DECISION DELEGATED TO HEAD OF PLANNING

Application No: H11-0127-25 **Applicant:** Mr A & Mrs L Hicks
Proposal: Extension to rear of dwelling to create new kitchen, lounge and study
Location: 31 Church Green Long Sutton Spalding
Terminal Date: 25th April 2025

CASE OFFICER ASSESSMENT

SITE PLAN  
SCALE 1:250

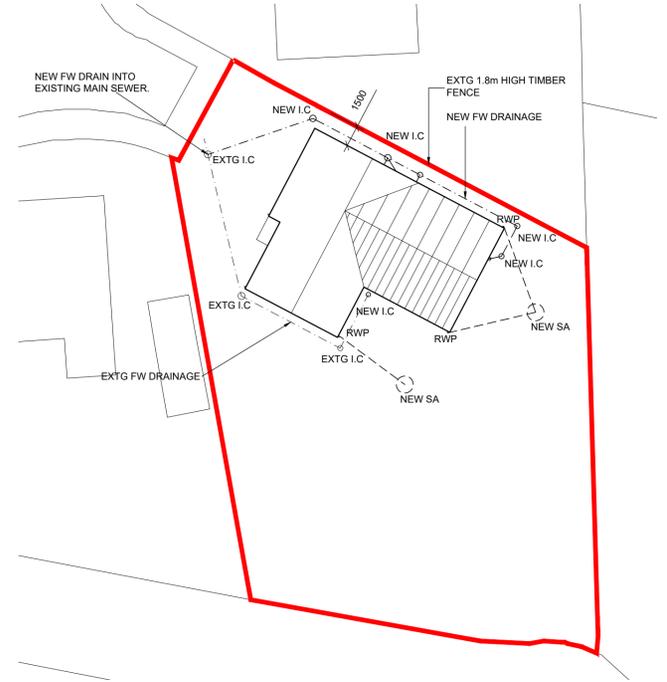
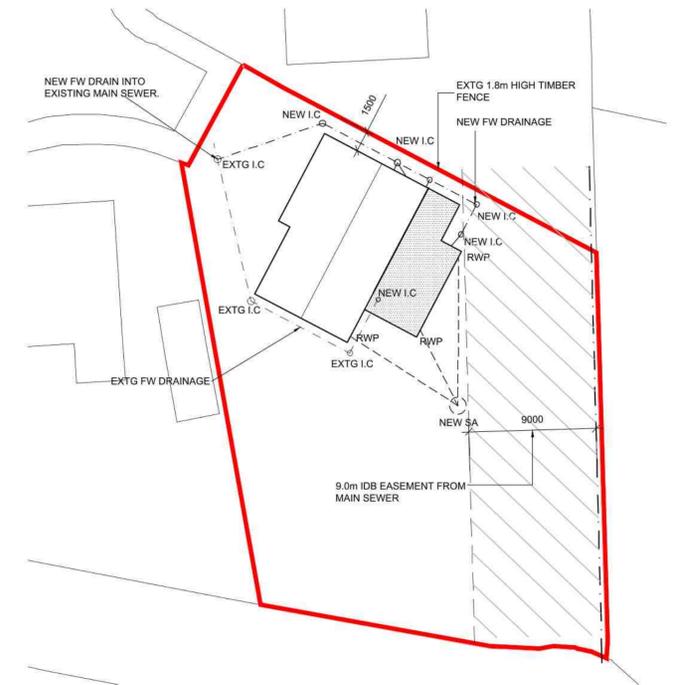
First Response (17 February 2025): The Board objects to the proposed development as the extension is within 9m of the Board's watercourse.

Second Response (01 April 2025): We are pleased to see that the applicant has updated their plans in response to the Board's comments. The applicant's initial proposal included the construction of an extension within 9metres of the Board's piped watercourse which goes against the Board's Planning and Byelaw Strategy. The applicant now proposes to construct the extension outside of the 9metre Byelaw Zone. In light of these changes, the Board would like to remove our objection.

PROPOSED REAR ELEVATION  
SCALE 1:100

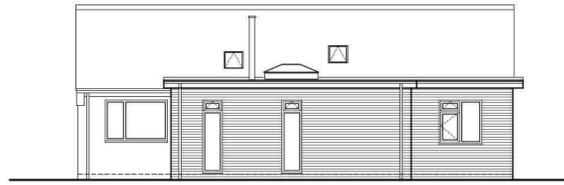
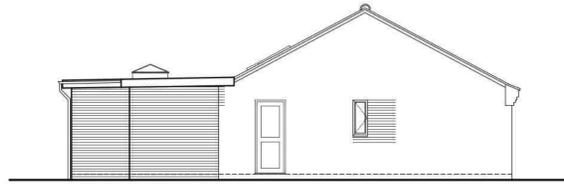
The proposed materials will match the existing materials, therefore helping to integrate the extension. The only difference would be the roof material which is a dark grey PVC single ply membrane as the main dwelling does not feature a flat roof. This material would not be visible from the street scene. The visual impact of the proposed development is therefore acceptable. The proposed development would not cause an adverse impact to the character or appearance of the area and would therefore accord with Policies 2 and 3 of the Local Plan and Section 12 of the NPPF.

PROPOSED FLOOR PLAN  
SCALE 1:50

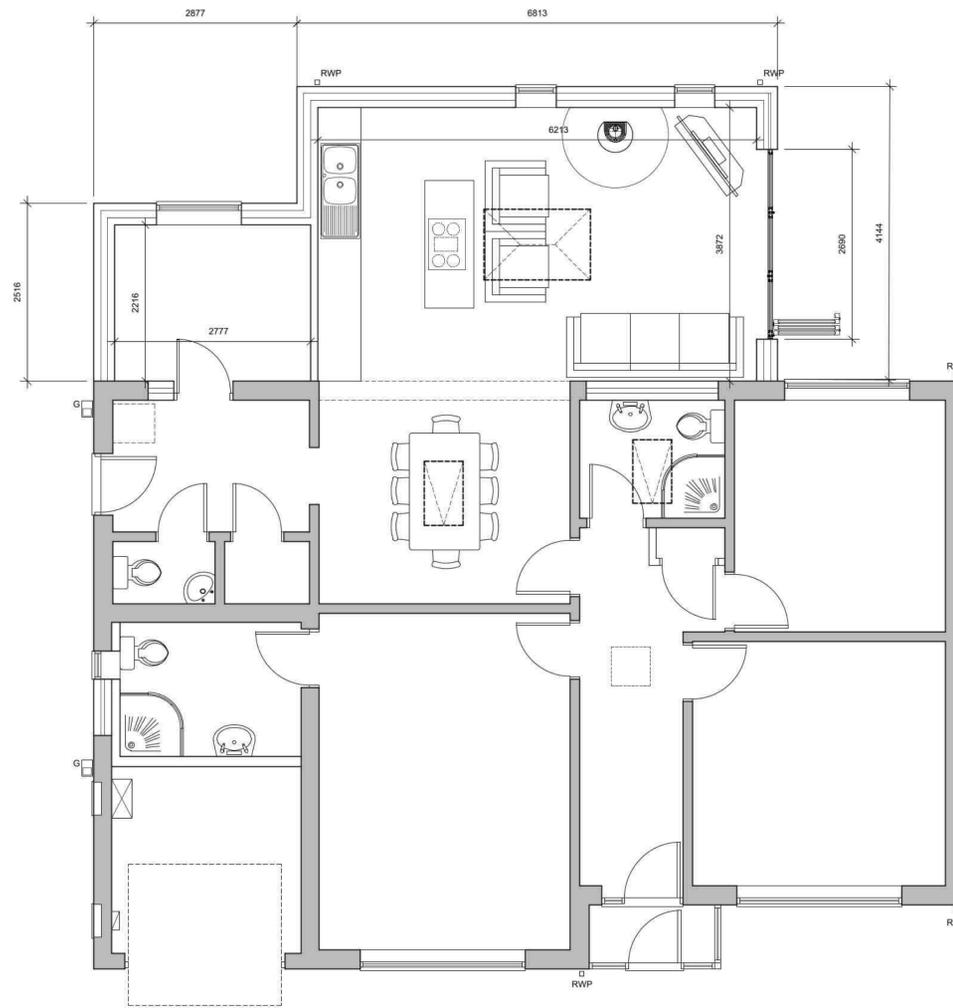
The proposals have been revised during the determination of the application. The extension was reduced in scale in order to avoid being within 9m of South Holland Internal Drainage Board's (IDB) watercourse. The revised extension features a flat roof form and is arranged in an L-shaped layout, whereas initially the extension was proposed to feature a gable end roof form. A period of re-consultation took place to allow neighbours and the drainage board to review the amended proposals.

No windows are proposed on the side elevation of the extension which faces onto the northern boundary with 30 Church Green. There is also a 1.8m timber fence between the properties to provide a degree of screening between the properties.
